RE: Legacy NAA Apartments 2
Conceptual Grading and Drainage Plan
Engineer's Stamp Date: 02/08/18
Hydrology File: C18D083

Based upon the information provided in your submittal received 02/02/2018, the Conceptual Grading and Drainage Plan is **not** approved for Site Plan for Building Permit. The following comments need to be addressed for approval of the above referenced project:

C-2

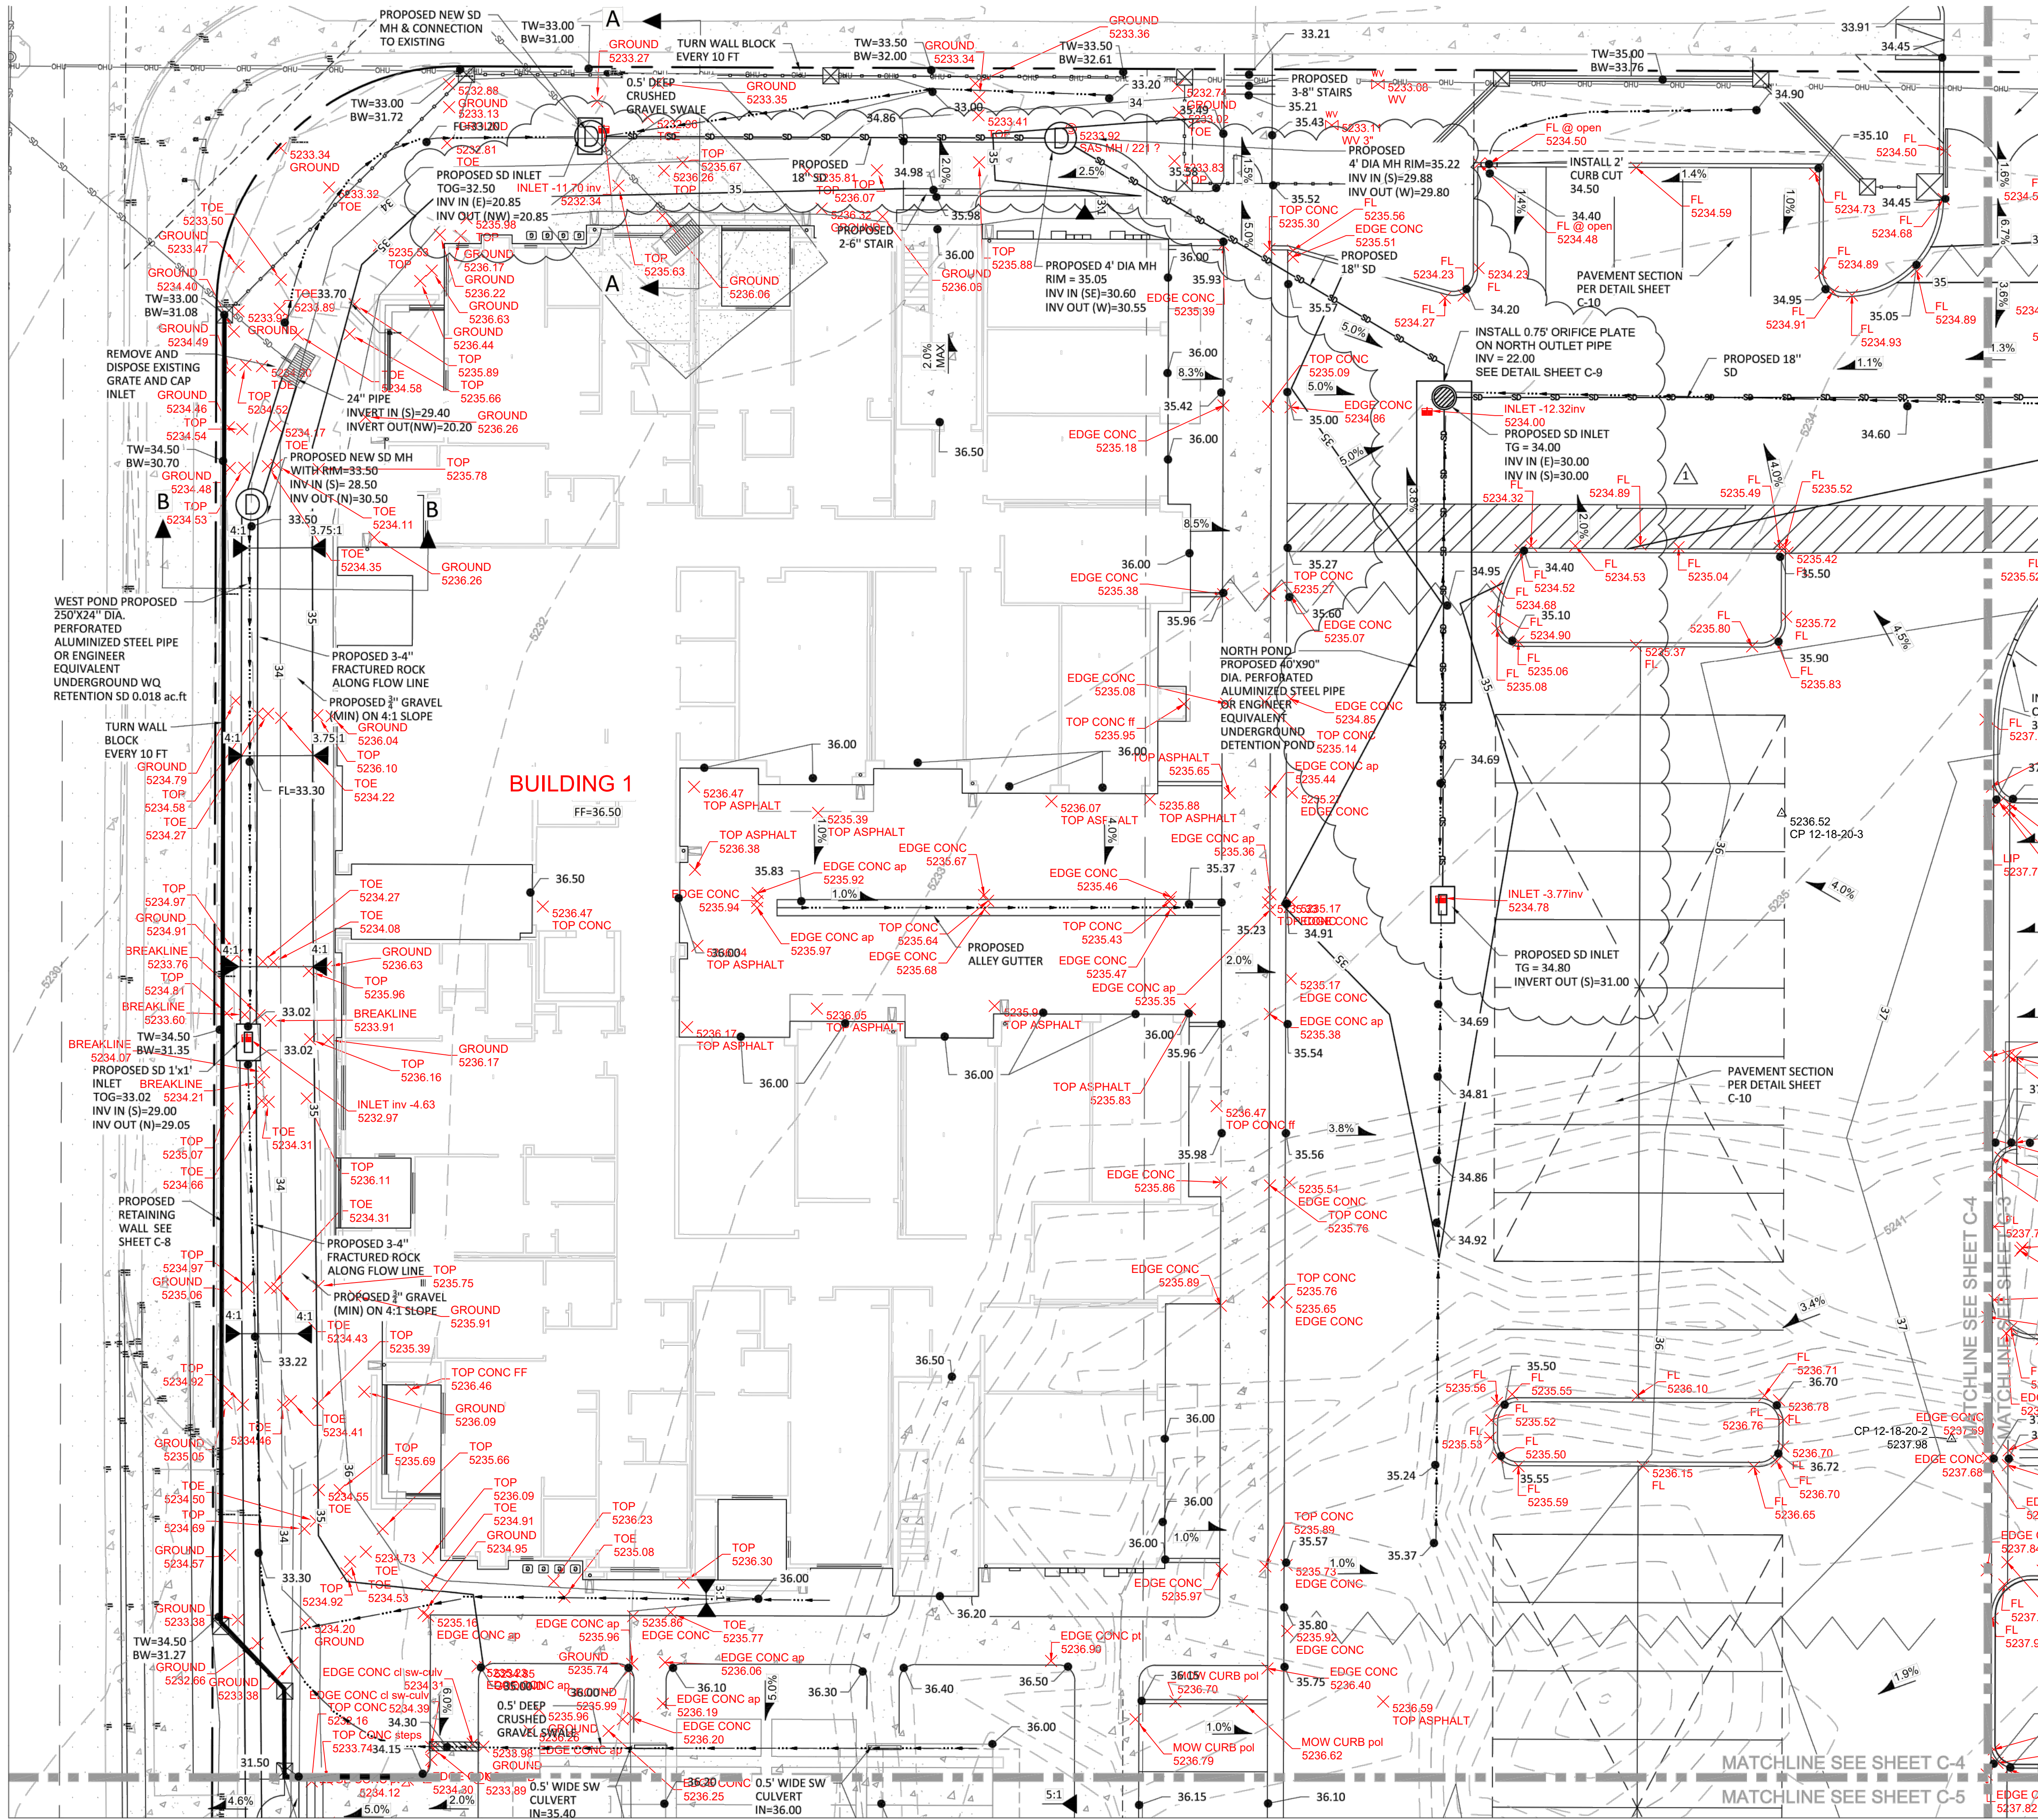
7. Sheet C-2. For Subbasin Northeast, the basin area and the proposed grading do not match. On Sheet C-1 there are drainage arrows starting at the edge of the parking going to the retention pond. On Sheet C-2, the drainage from the south half of the parking goes to a swale along the edge of the parking and into Subbasin North. Please correct.

8. Sheet C-2. For Subbasin East, How is the drainage actually getting into the retention ponds? Especially the eastern pond. Should there be a connecting pipe between all three retention ponds? Please explain or correct.

9. Sheet C-2. For Subbasin East and Northwest, the retention ponds needs to have a spillway for the volume over the 100 – 10day. Please add spillway.

SHEET NUMBER:  
**C-1**

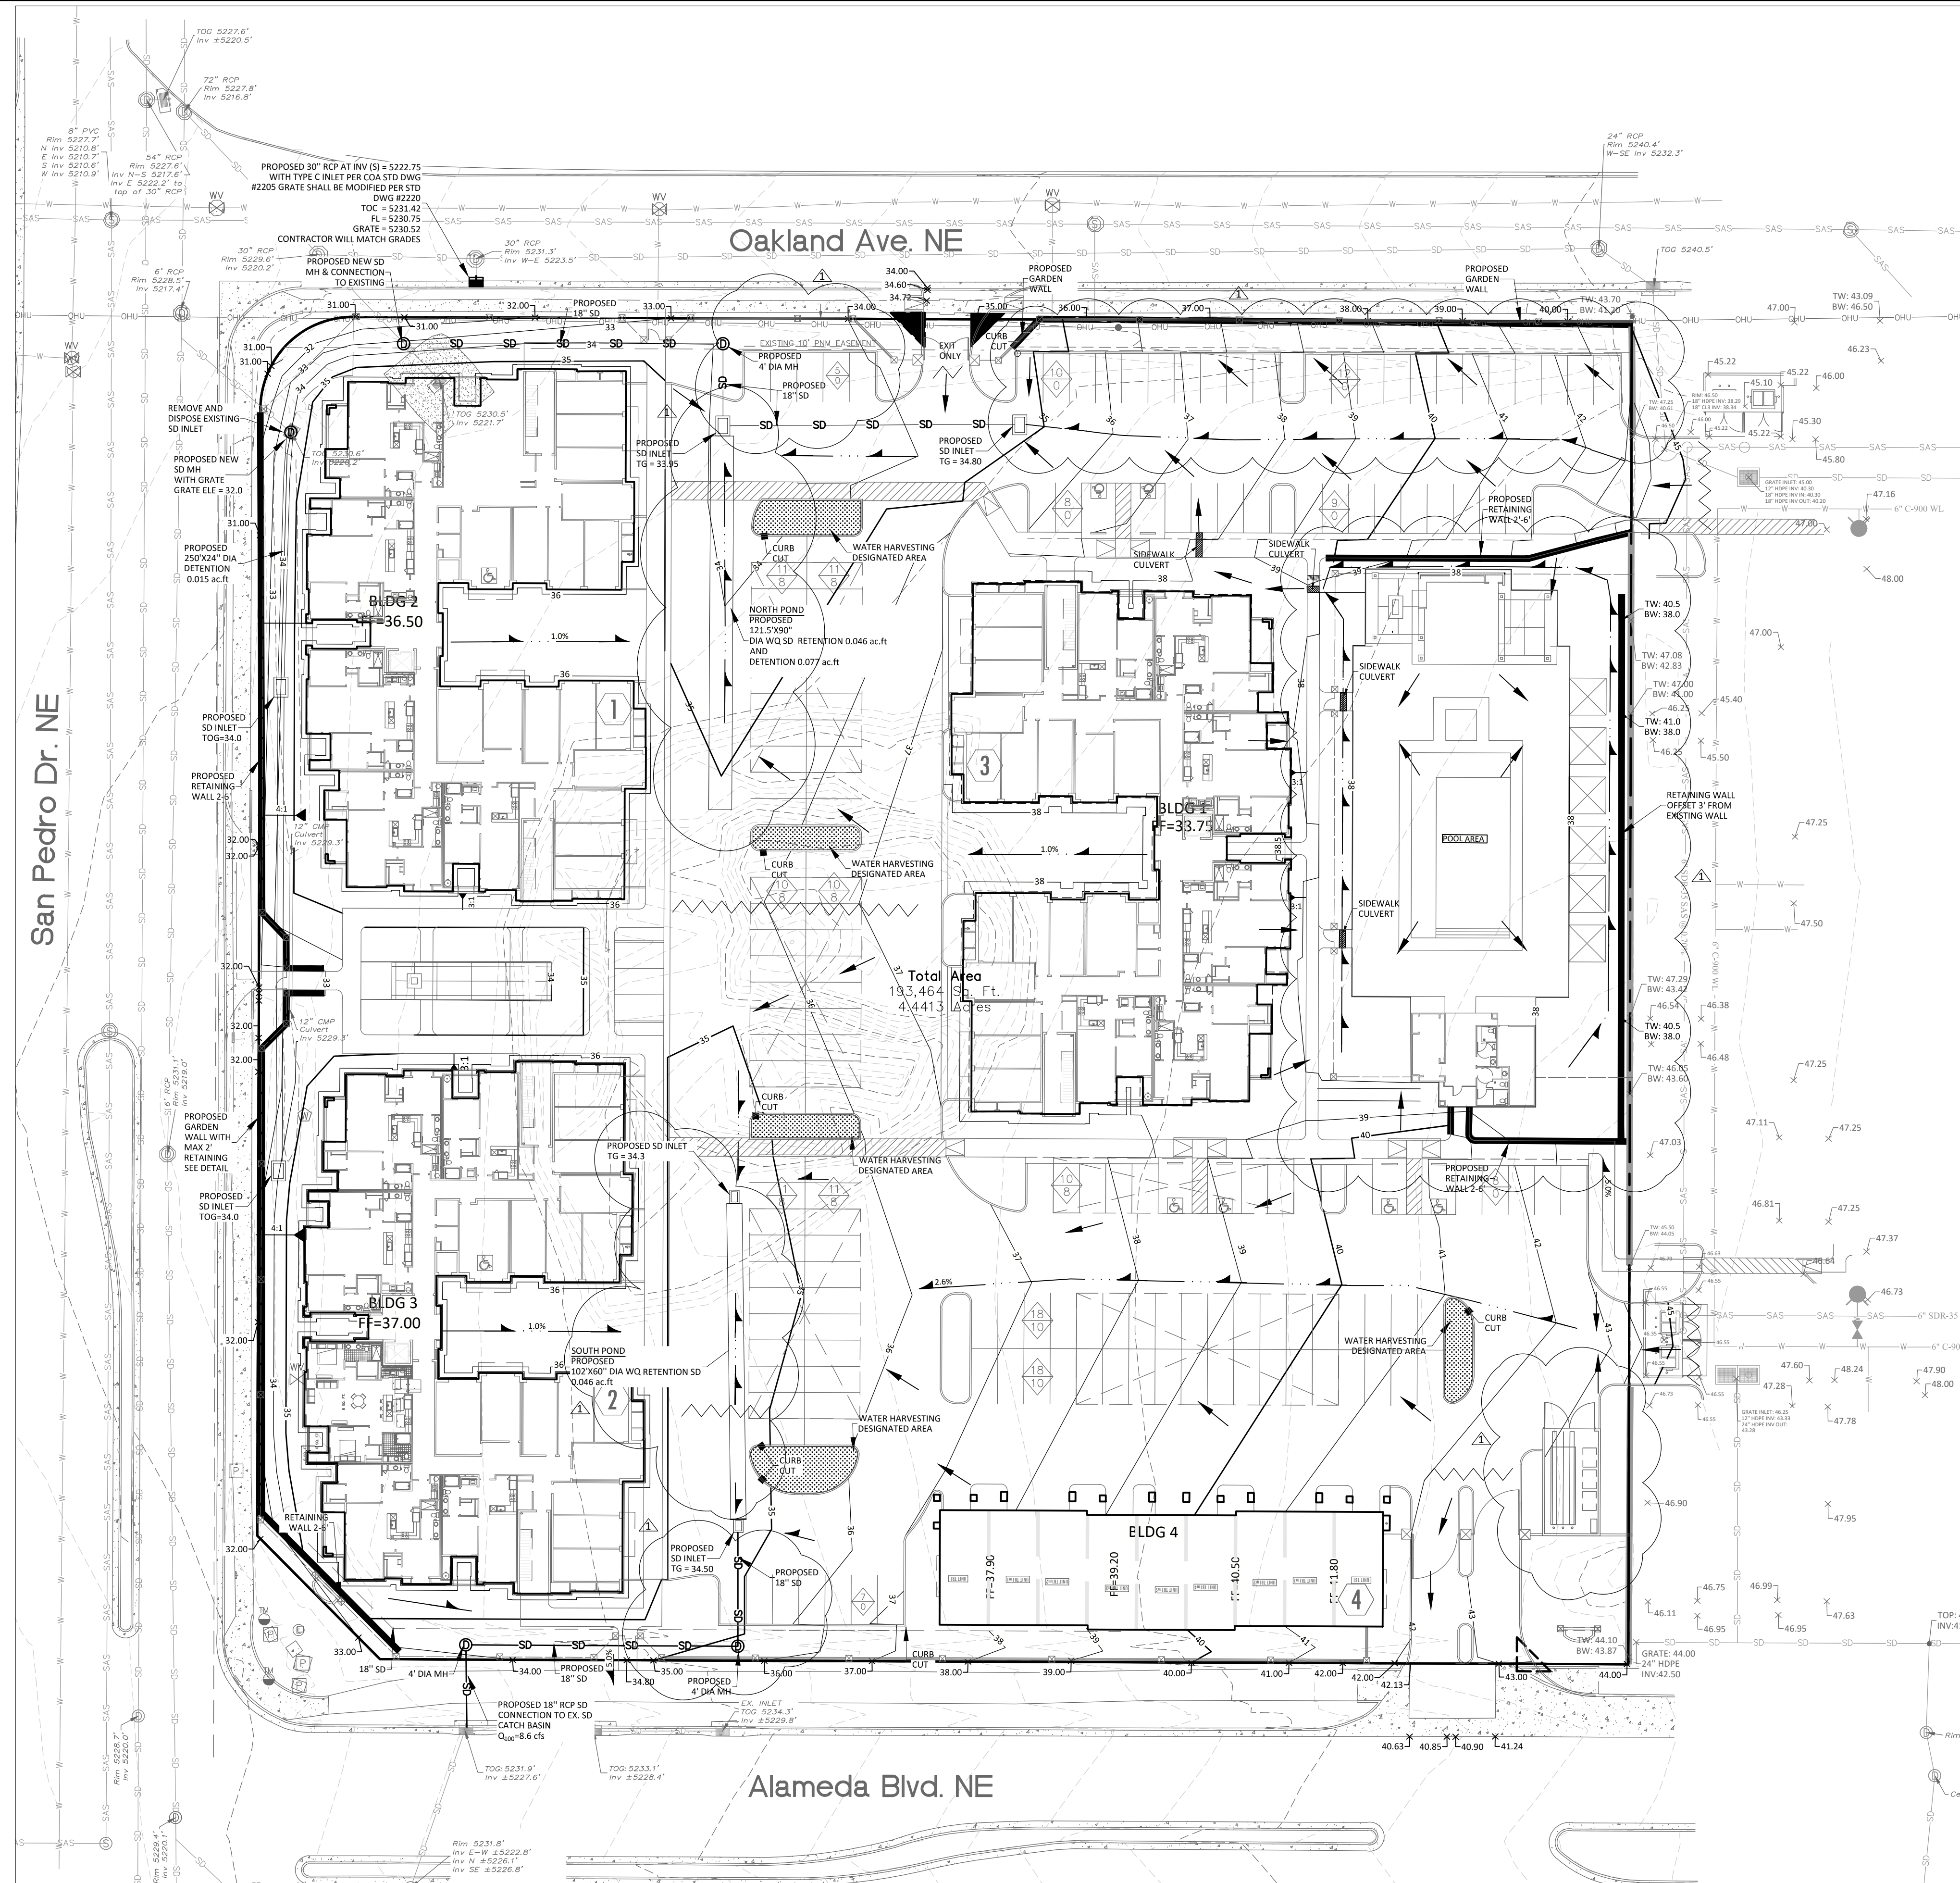
1. Please add the word "Conceptual" to the sheets title and add a note stating "Not for Construction".
2. Sheet C-1. Under Background, the southern half of the property is tying into the existing storm inlet on Alameda Blvd. This was installation with modifications to the NAAMDP under a design analysis report "Alameda Blvd San Pedro to Wyoming Project #7663.91 by Thompson Engineering dated January 2012. This report revised the allowable discharge for the southern half of the property to 3.82 cfs/ac. So the 2.21 ac will have an allowable discharge of 8.44 cfs.

3. Sheet C-1. The Q_{100} for Subbasin East should be 2.09 cfs.
4. Sheet C-1. Please clarify if the retaining walls along the East property line are existing or proposed. If it is proposed, then please show a cross section.

5. Sheet C-1. Please show the retention pond volume calculations for both Subbasin Northeast and Subbasin East for the 100 year – 10 day.

6. Sheet C-1. For Subbasins North, West, and South, please show the first flush volume within the landscape areas. The first flush volume is for water quality purposes. Having this volume just within underground pipes does not fulfill the intent of the first flush basins. Please revise and show how the flows into and exists the first flush ponds.
